RE: Congress Apartments
Grading and Drainage Plans
Engineer's Stamp Date: 08/5/22
Hydrology File: C13D033

Based upon the information provided in your submittal received 8/5/2022, the Grading & Drainage Plan is not approved for Building Permit until the following comments are addressed:

SECTION A
NTS C.5

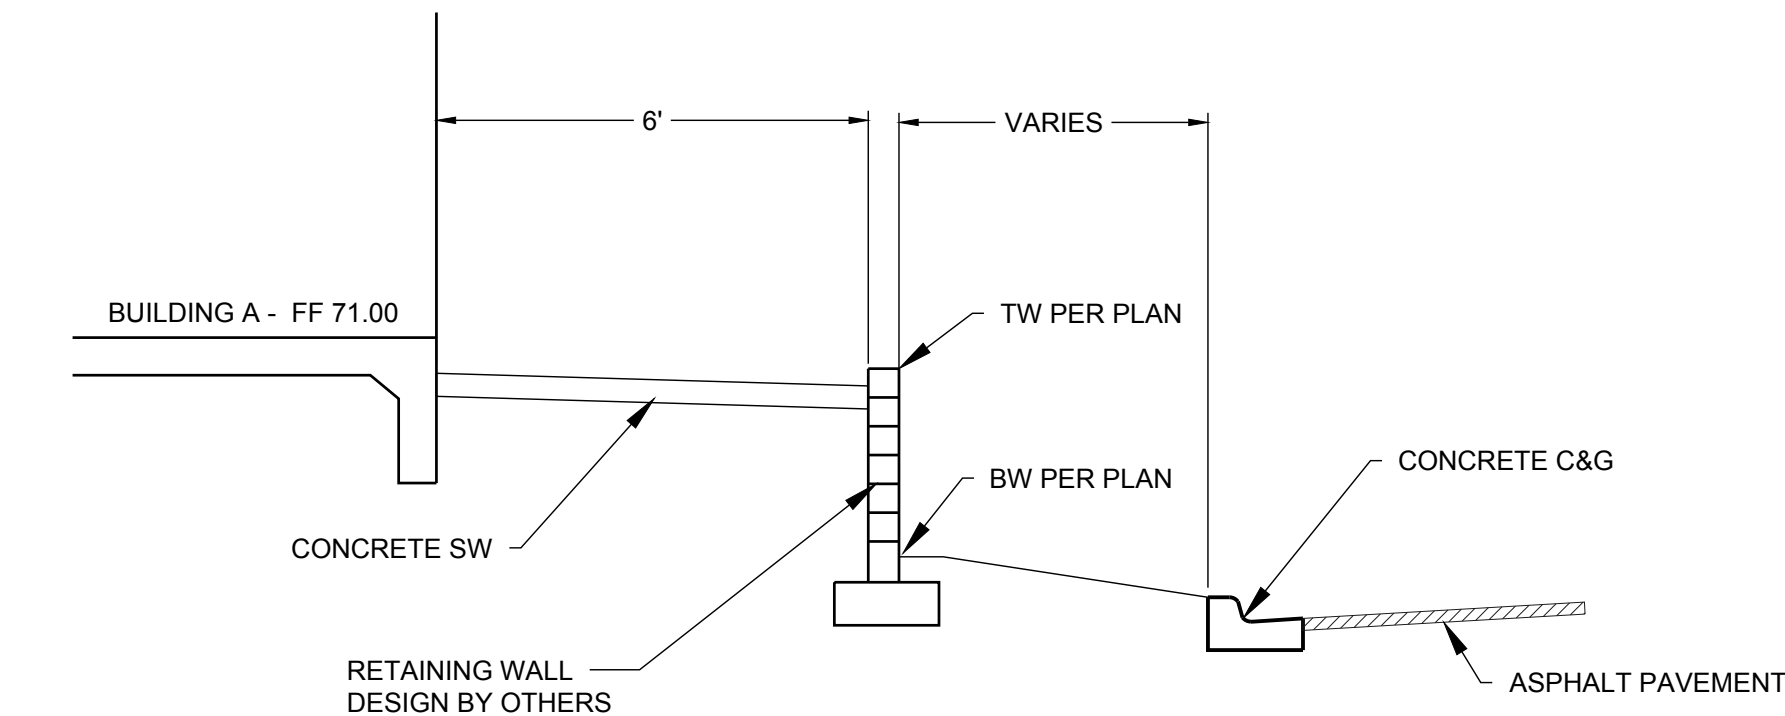
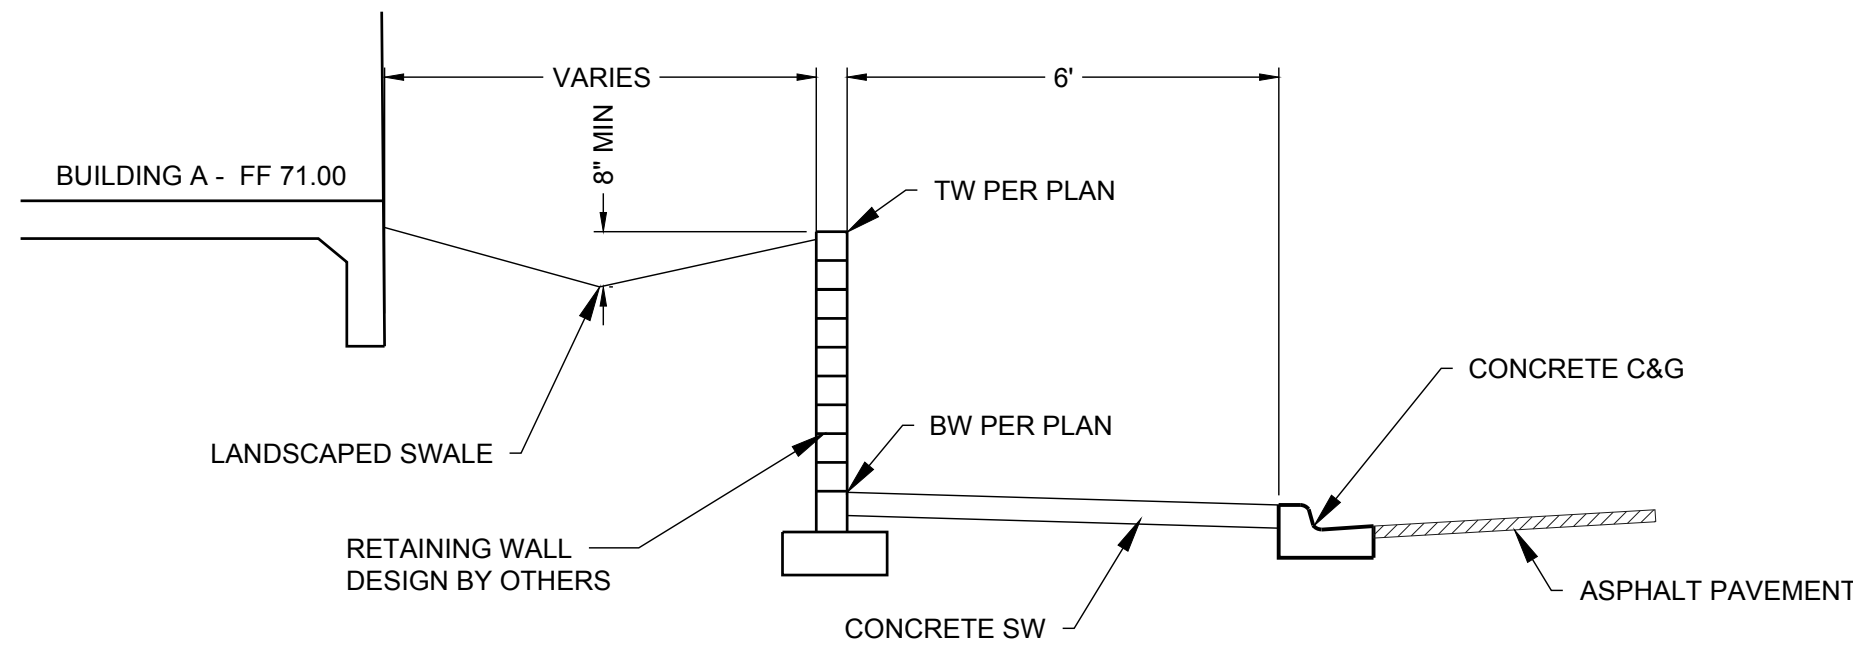
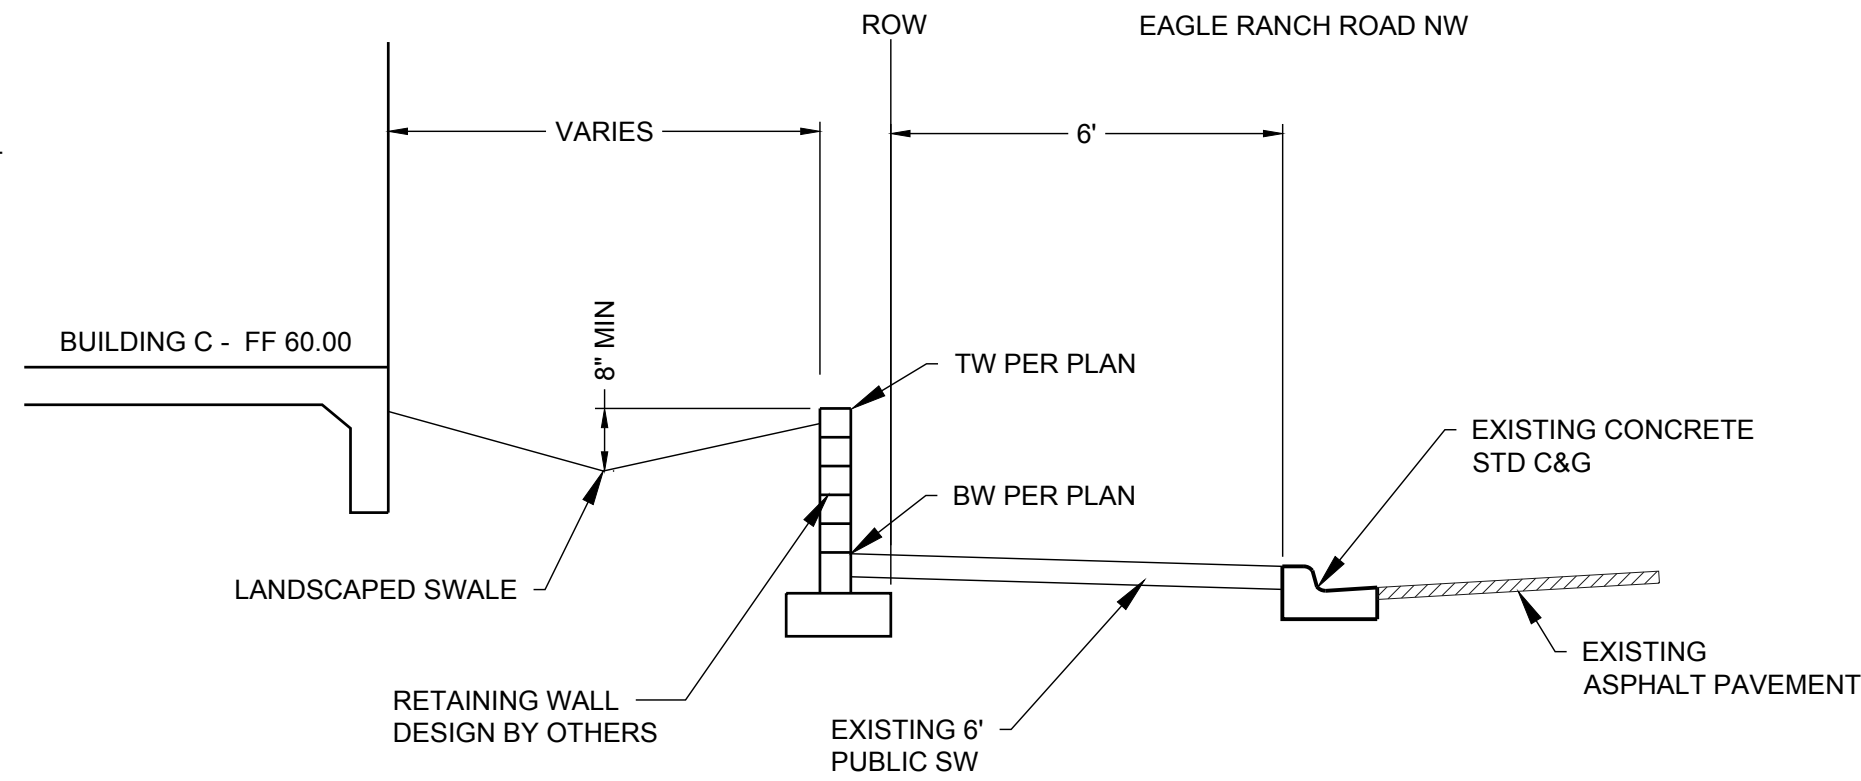
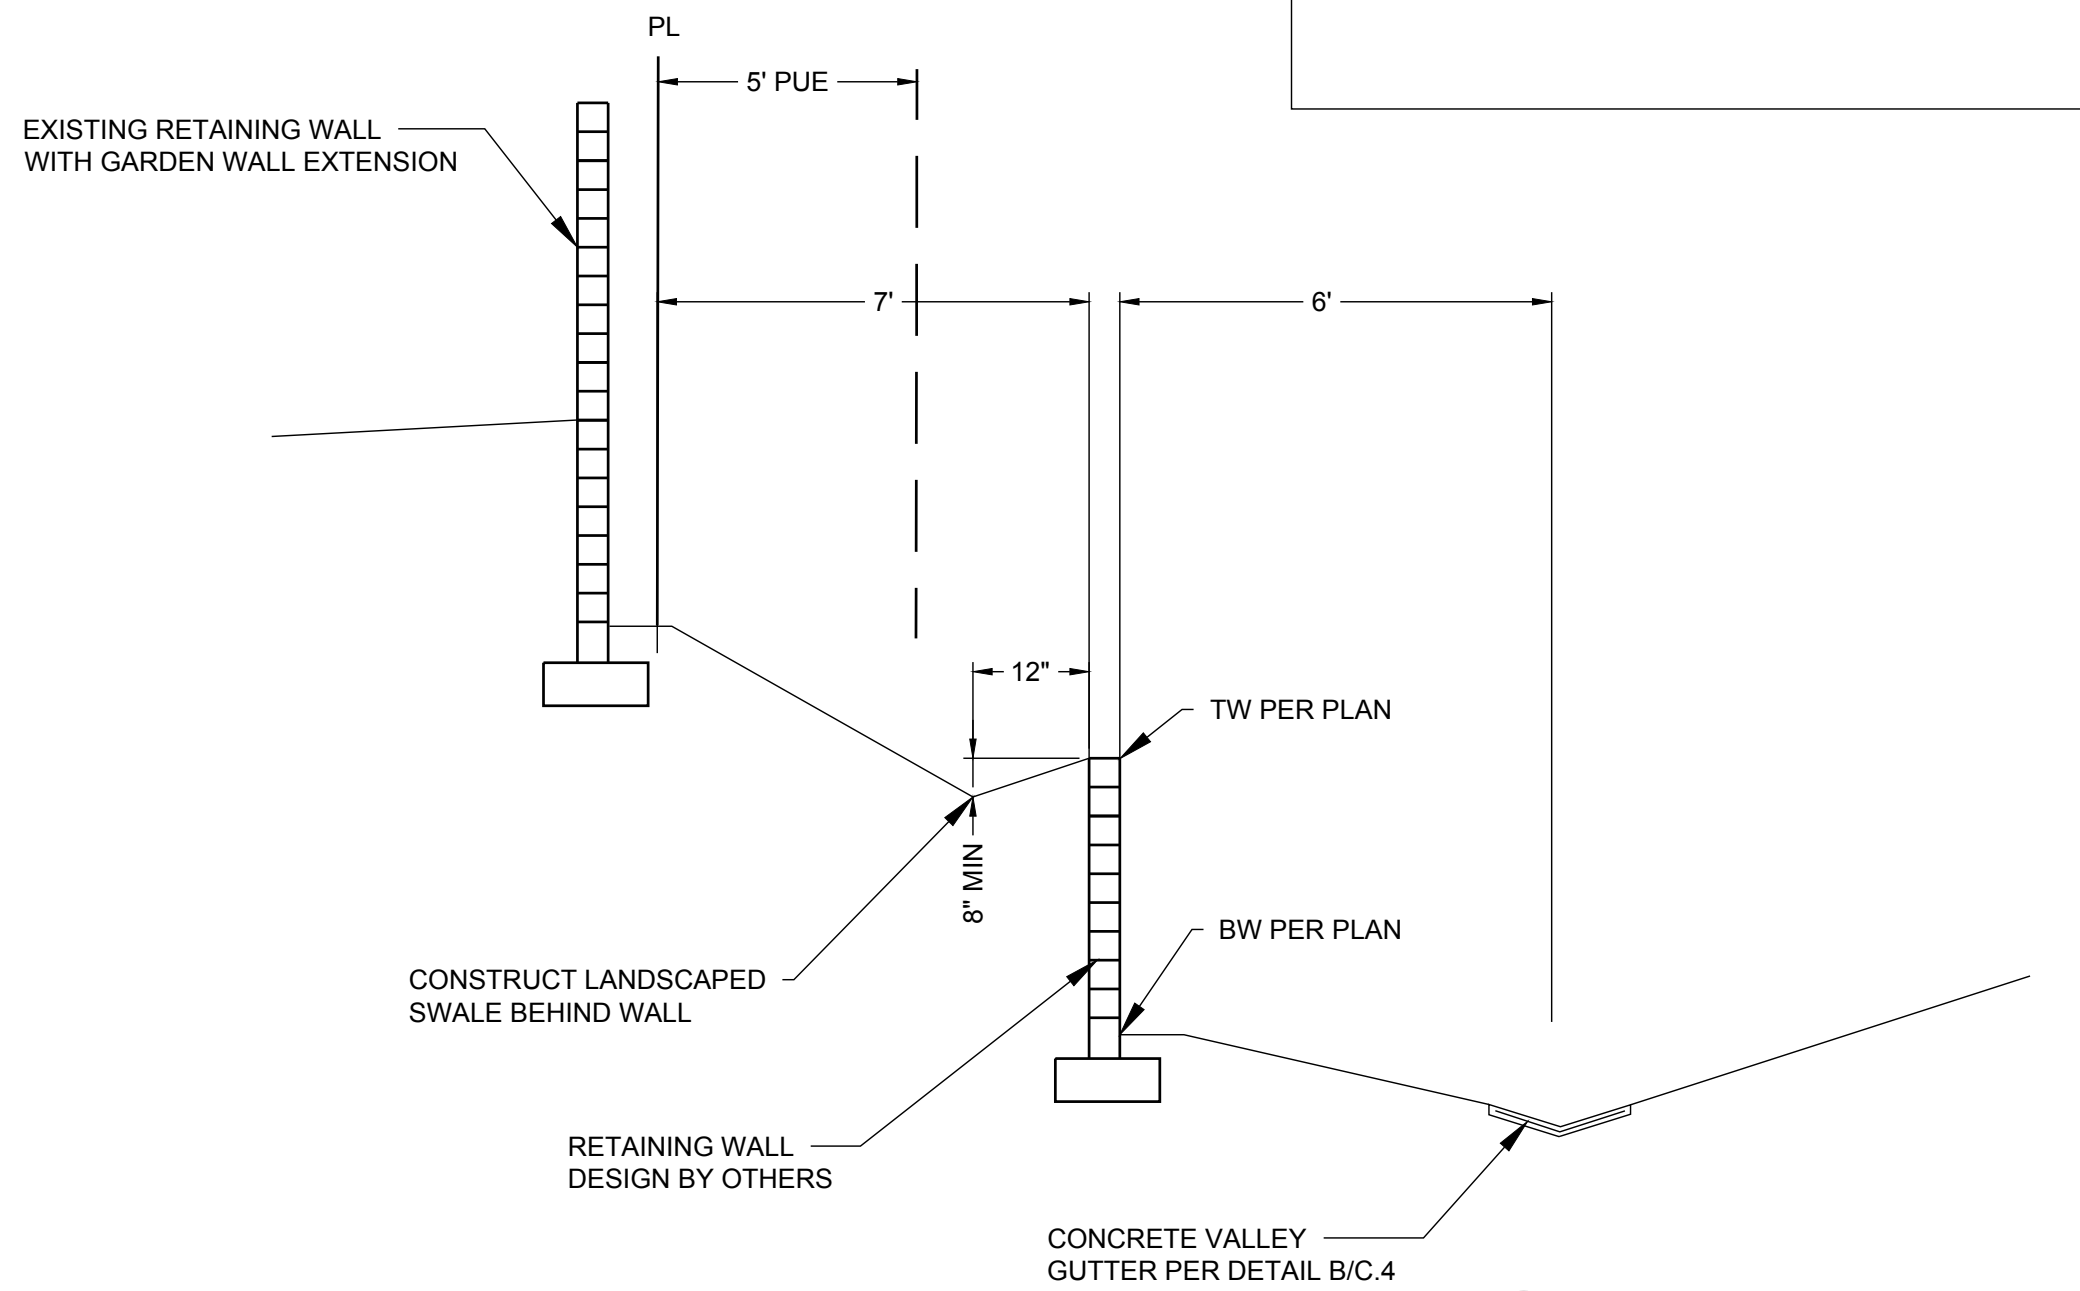
6. On the retaining wall plan , provide TW/BW rather than TW/FG as sometimes FG grade is higher and lower than the TW grade.
7. What is the significance of the linework that juts into the drive north of the parking area between buildings B and C?
8. For Sections B, C, D and E on Sht C.4 provide the depth of the invert in the landscape area.
9. Pond slopes are to have aggregate. This comment may be moot per comment 2.a.
10. From reviewing contours in our GIS, it appears that north-bound Eagle Ranch Rd is lower than south-bound Eagle Ranch Rd. Please confirm with spot elevations at the northbound flowline to justify not providing the standard water block of 0.87 inches at the property line.
11. Please increase the font size for the First Flush Criteria.
